**ANGEL PLACE
LEVEL 8, 123 PITT STREET
SYDNEY NSW 2000**

19 DECEMBER 2022

TOGA CENTRAL (FORMER PARCEL POST BUILDING)– SSD-33258337 - RESPONSE TO SUBMISSIONS (BUILT HERITAGE)

This letter has been prepared in response to the agency comments relevant to SSD – 33258337. This letter specifically responds to the heritage comments provided in the following:

Figure 2: Ground floor plan (left) and Levels above ground level (right) with area of concern outlined in green

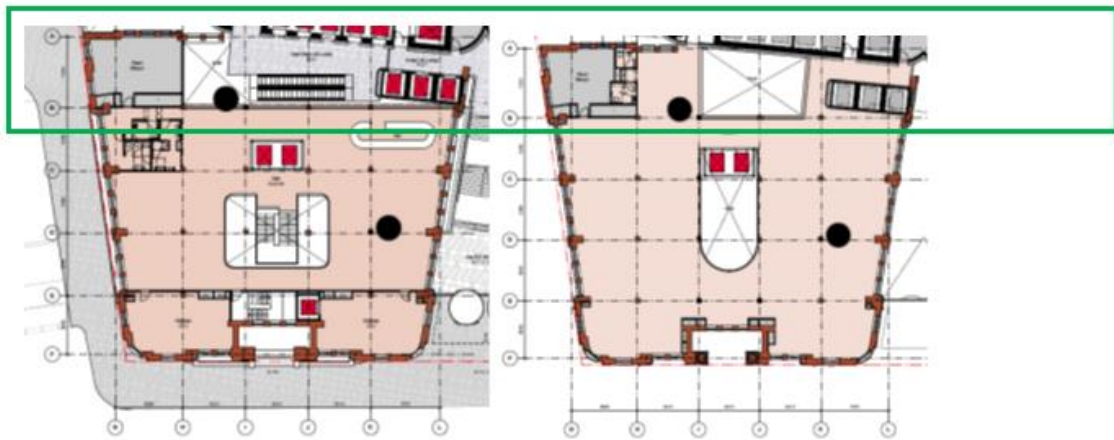
Of particular concern is the quantum of insertions proposed within the building between Grids A and B (see Figure 2 below), which reduces the floor plates to a fragmented series of passageways. The plant room, column, void and lift core result in almost total demolition of the floor plates in this area

In particular, the proposed escalators are not supported as they alter the historic character of the building. Additionally, the demolition of fabric raises concerns of the potential risk of damage to significant internal detailing of the stucco of the internal columns.

- *Consideration should be given to whether the proposed escalators and the lift core comprising three lifts servicing up to Level 19 between Grids K and L would be better relocated into the southern pod from a heritage perspective.*
- *The extent of insertions between Grids A and B should be minimised.*
- *A specific heritage asset construction methodology should be required to review the current proposed construction methodologies and to detail mitigation measures to limit potential risks to the internal columns and finishes.*

The proposed design has been revised to minimise the extent of the internal insertions and voids within the fPPB. It is acknowledged that the same quantum of insertions is proposed however, this revision minimises the scale of the insertions in line with CMP Policy 61.

The proposed relocation of the escalators and lift core between grid section K-L has been investigated however has been discounted from the revised design due to structural and operational feasibility. The presence of escalators and lift cores has been situated in this space as the most practical and logical option, to provide necessary structural stability with as little intervention into heritage fabric as possible. The core occupies an area to a corner of the building and it is not prominent within the floorplate. However, other modifications to the design as noted above will mitigate the impact of locating the escalators and lifts in this space.

The central atrium and stairwell will be reduced at lower ground and ground floor level to be in keeping with the levels above. In its prior design the atrium included a larger void over C-E and H-K from the lower ground level and up, with the overall central stairwell reducing in size to the upper levels. The modifications to this design will reduce the expanse of the stairwell and void above to within the C-E and I-J only. This change will subsequently result in the reduction of internal intervention into existing fabric.

To further reduce the amount of demolition and disruption to interiors, the plant rooms previously proposed to be located adjacent to the interior of the eastern elevation have been setback further away to the west. The legibility of the interior of the north east corner will therefore be somewhat enhanced.

As discussed with regards to the above recommendation, modifications to the design have considered the scale of intervention to fabric between grid section A-B. The scale of internal demolition and intervention in this area has also been reduced overall as seen in the modification to the void space, the plant room and further consideration to the location of the escalators and lift core. In short, the overall amount of internal demolition required has been reduced where possible and will result in a more acceptable use of the space from a heritage perspective.
